RE: Cockle Bay Marine Structures Redevelopment – Response to Heritage Council's Comments

The NSW Heritage Council have provided comments to the Maritime Archaeology Statement of Heritage Impact (MASoHI) report in the form of six comments relevant to the MASoHI report that require a response (NSW Heritage Council document EF14/23309). This short report provides the responses to each point as part of the formal submission to Heritage Council's comments. The sixth comment in the Heritage Council submission regarding the listing of the exposed section of seawall is not directly relevant to the MASoHI and is not addressed in this short report.

Cockle Bay Marine Structures
Developed Design
General Arrangement Plan

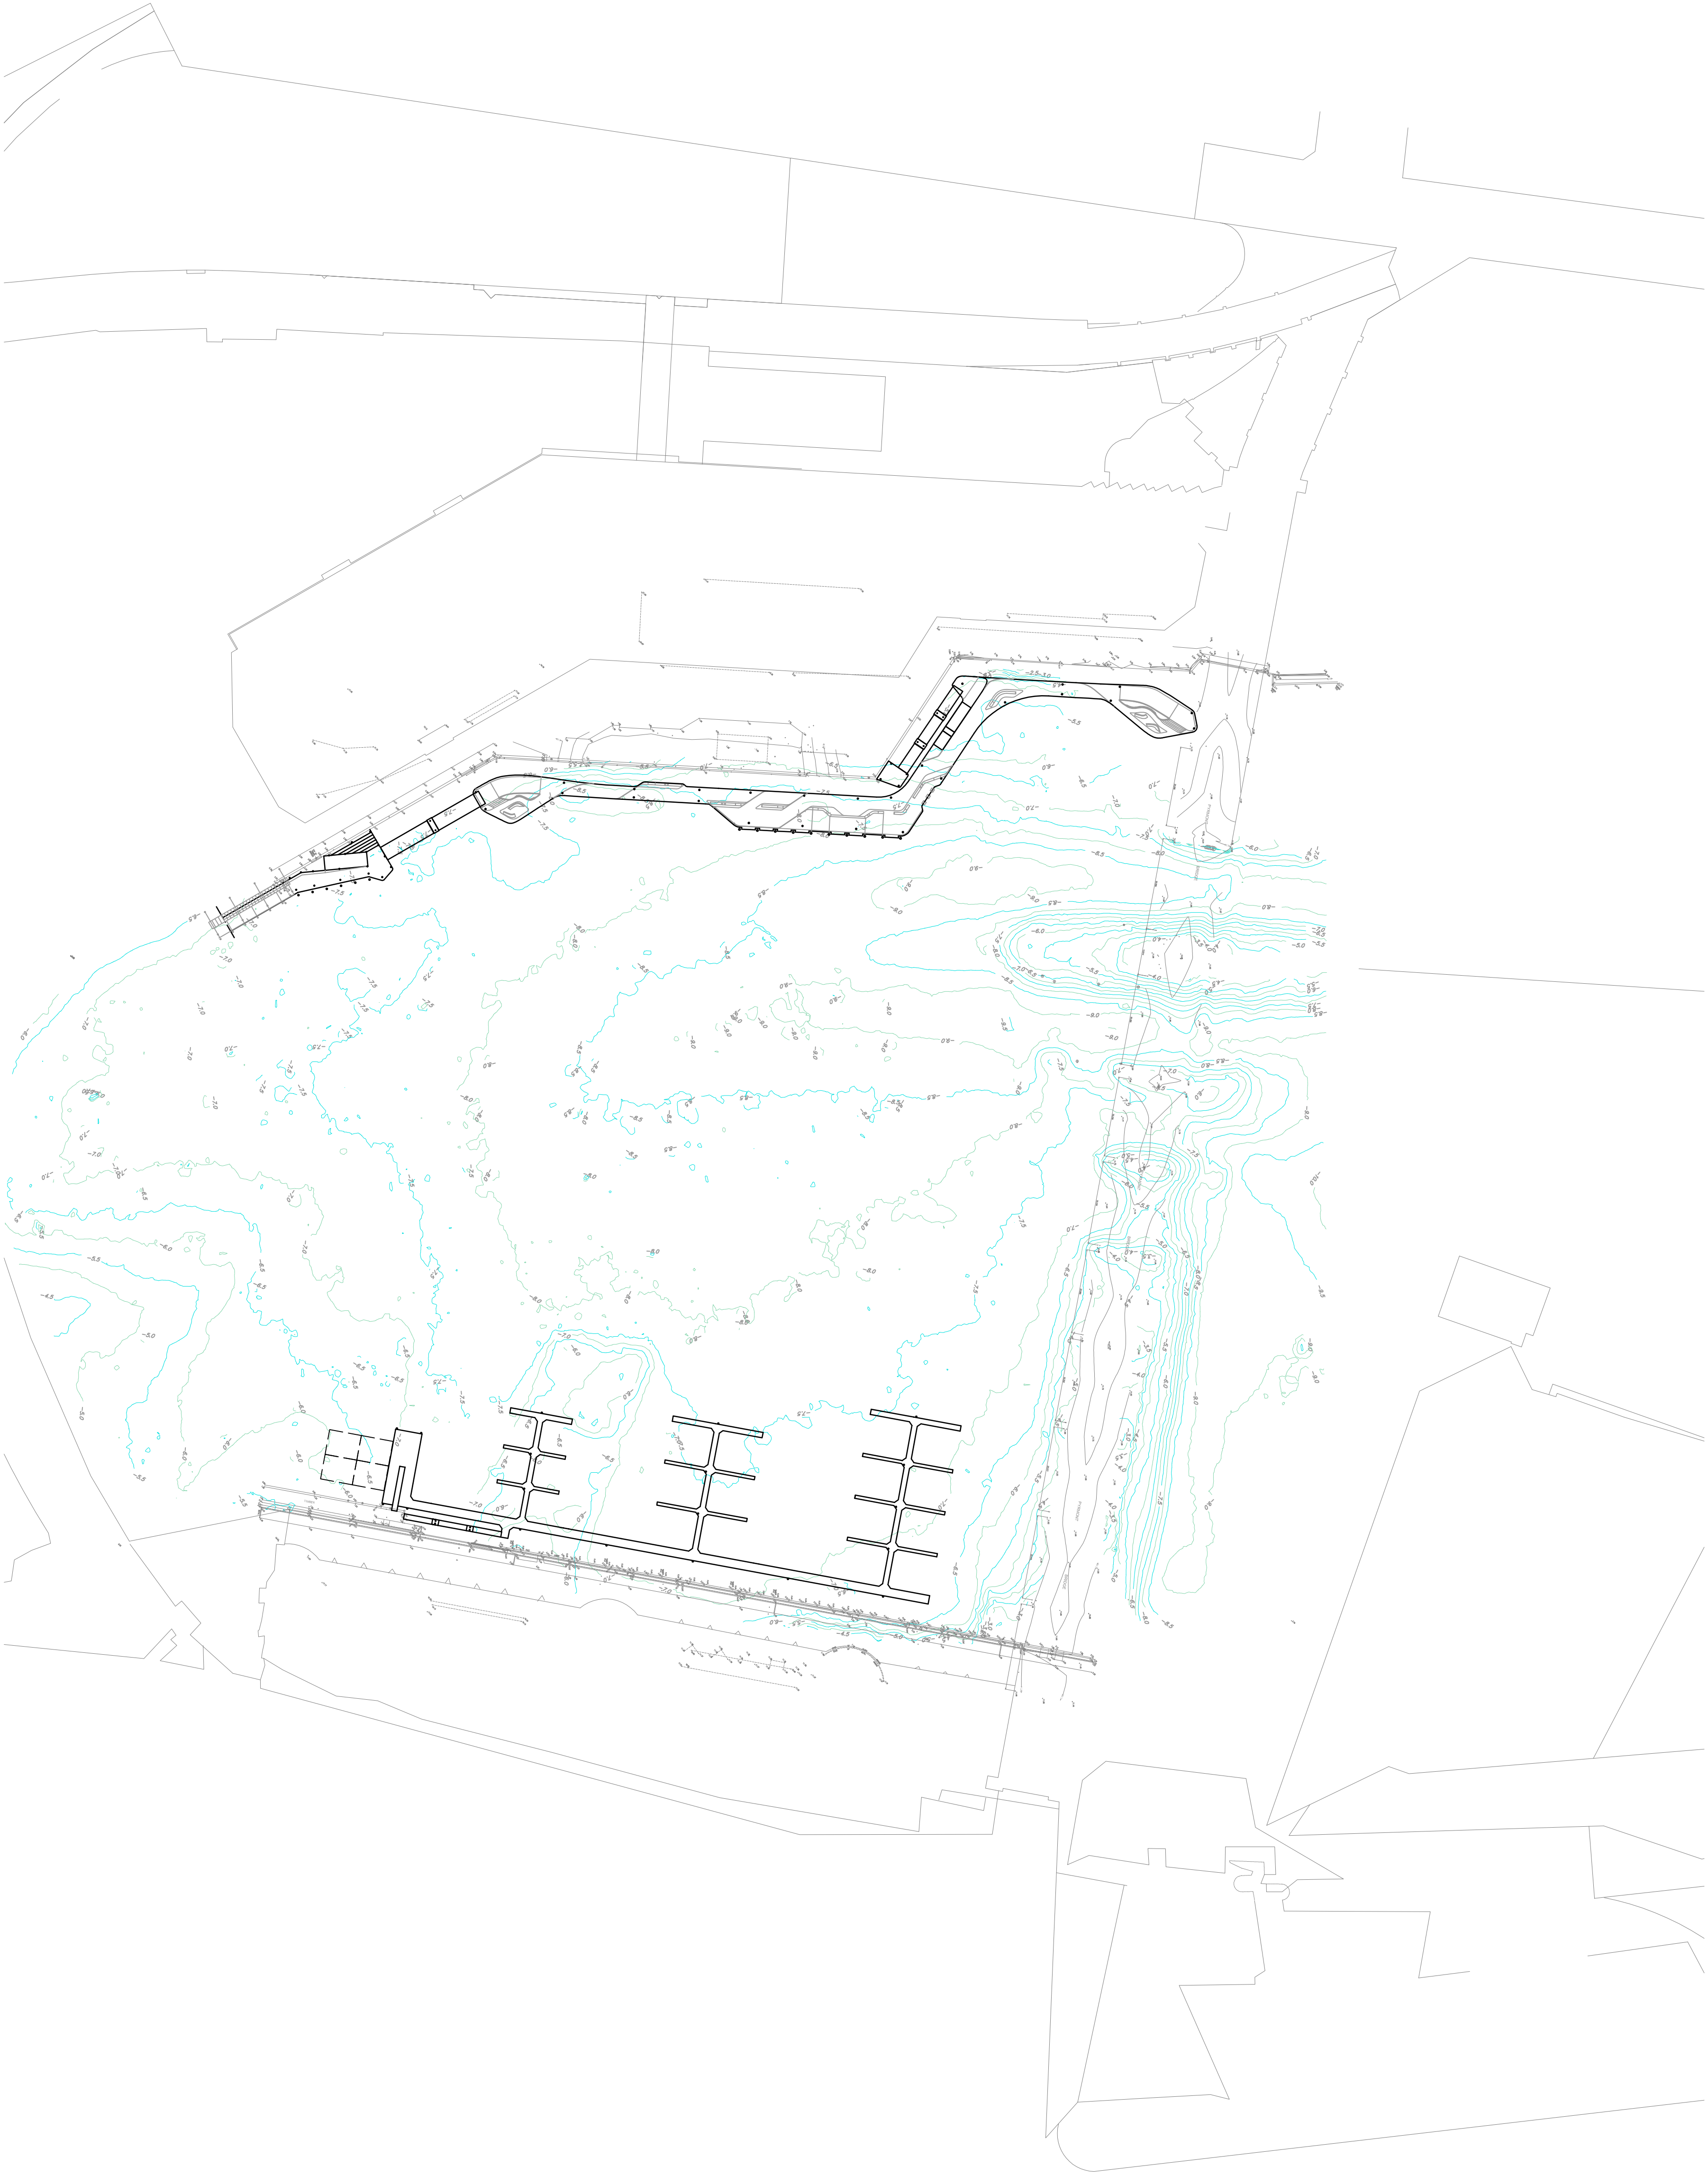
The EIS states there is a high potential for remains associated with previous wharves, jetties, and activities in Cockle Bay buried below sediment that has accumulated since the last dredging in the 1980s. This is representative of the earliest maritime infrastructure in Sydney Harbour and is considered to have State heritage Significance (EIS section 8.11.3). Physical remains evidence in the survey only identified modern debris and high sediment content. The MAS&SOHI and the EIS did not provide a specific assessment of the effects of the proposed piling on these phases of occupation or their likely significance. The EIS needs to compare the known phases of occupation and relics against the proposed piling locations in order to assess any likely impacts.

The MAS&SOHI and EIS have not considered the impact of this proposal on the state significant archaeology. The proposal has stated that the piling will cause harm to state significant archaeology within the seabed. On this basis, it is recommended that any impact should be minimised as much as possible through a careful consideration of the pile design in this area. The mitigation of the loss of state significant archaeology should be clearly outlined in the EIS prior to any approval of the SSD by the DPE. It is recommended that upon receipt, DPE refer this additional information to the Heritage Council for consideration of its adequacy and to advise DPE of any additional conditions of approval that may be appropriate.

A significance assessment for the wharves constructed in Cockle Bay between c1830 and 1970 was prepared in section 5.2.1 of the MASoHI report. An impact assessment was also undertaken for the proposed works in section 6.3.1 of the MASoHI report.

The following table compares the location of proposed piling works to the identified building phases based on historical plans of Cockle Bay used in the MASoHI report.

The potential impact of the piling works on the identified state significance archaeological remains identified in the MASoHI report has been addressed in section 6.3.1 of the report. The report stated that:

Pile type and locations have been designed to minimise the total number of piles while still being able to allow for the design of the marine and floating walkways. The mapping provided (see Dot Point 3 above) shows that few piles will have a direct impact directly or immediately adjacent to the location of former wharves constructed in Cockle Bay, and the diameter of the piles – 400 mm – has been kept as narrow as possible. The likelihood of one of the piles intersecting the remains of a pile from an earlier jetty would be minimal.

In addition steel piles are hollow, so impacts could be confined to the piercing or breaking through of larger features such as collapsed piles and/or headstocks – should they be present – with smaller objects being pushed away or encased within the pile.
